Application by Thurrock Power Ltd for an Order Granting Development Consent for the Thurrock Flexible Generation Plant Project

Response to Procedural Deadline D

Specialist Archaeological Advice

20/00273/DCO Thurrock Flexible Generation Plant, Fort Road, Tilbury

Figure 20

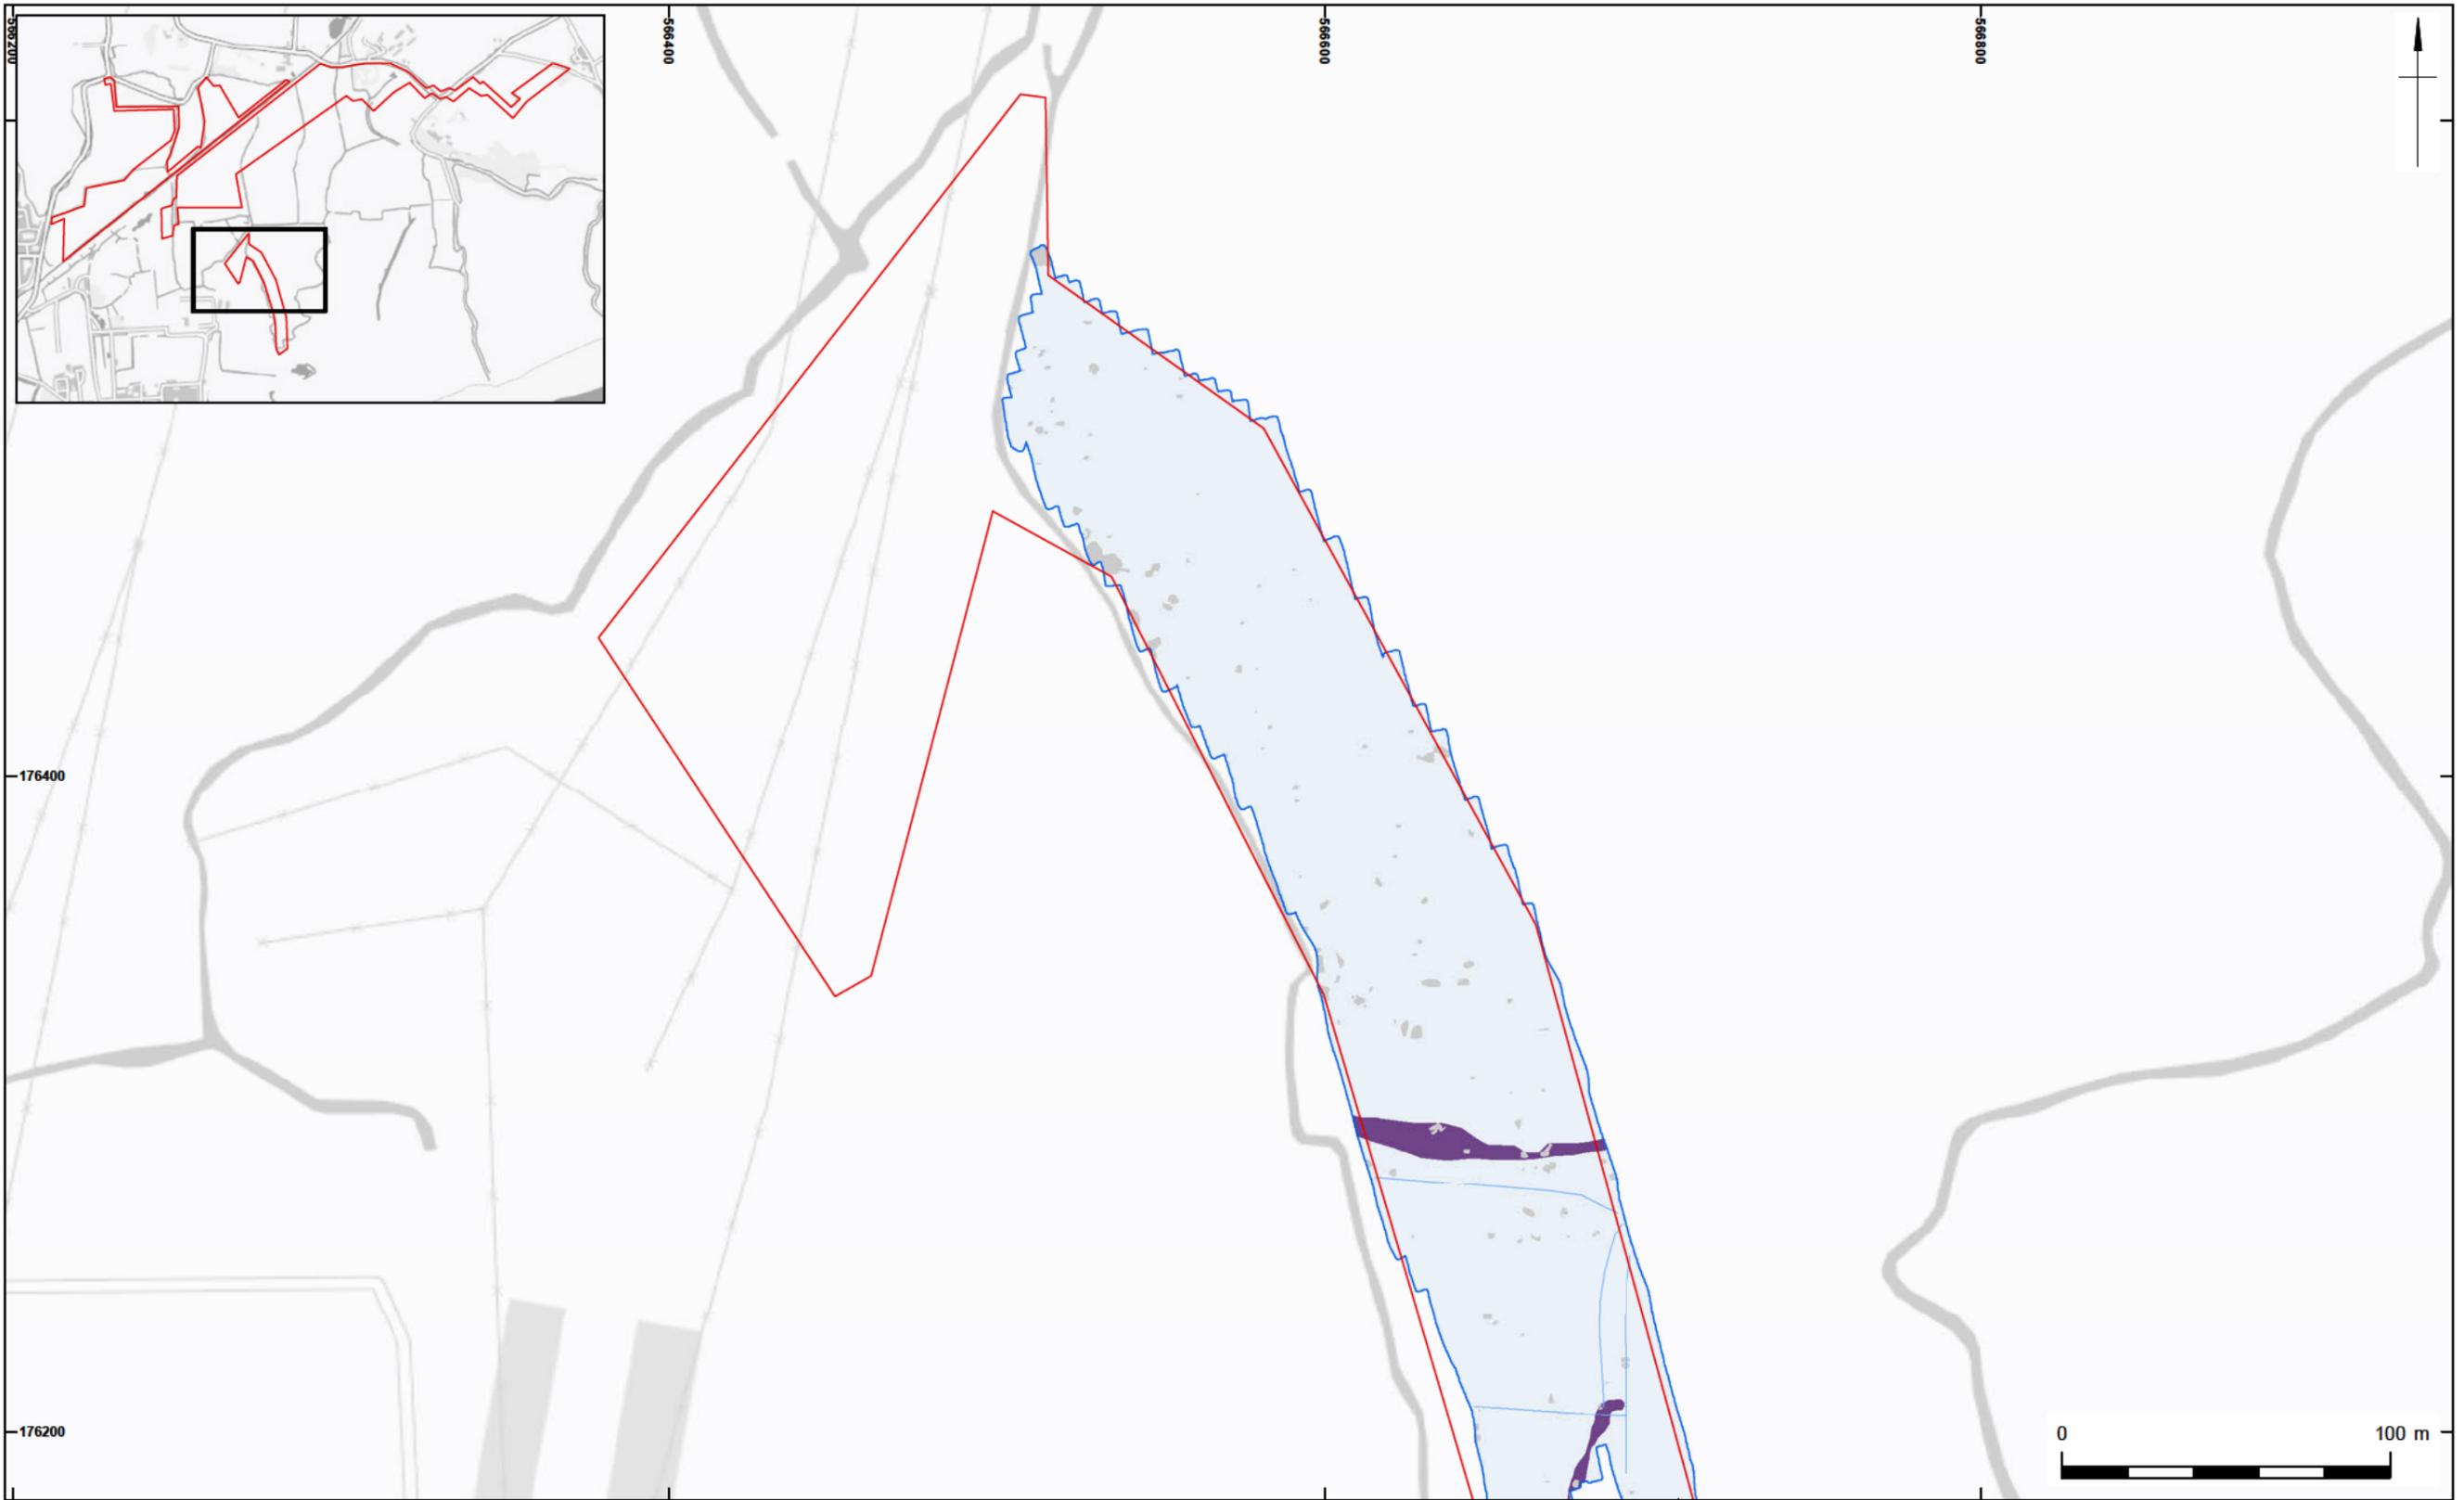
It is pleasing to see that in the documents provided in December that geophysical surveys have been undertaken on the majority of the development area. This provides basic data which can be built on to facilitate an understanding of the historic environment so that the inspector can make an informed decision on the impact of the development. It is disappointing that the applicant does not have the detailed results of the geophysics as the present document provides little detail on the results.

These results also need to be ground truthed to have an understanding as to what the features represent. Large scale developments in the area have shown extensive red hill (saltern) complexes surviving within the grazing marsh area. Similarly, the Lower Thames trial trenching, being undertaken to support their DCO submission has shown an extensive archaeological site of Roman date at the eastern end of this application.
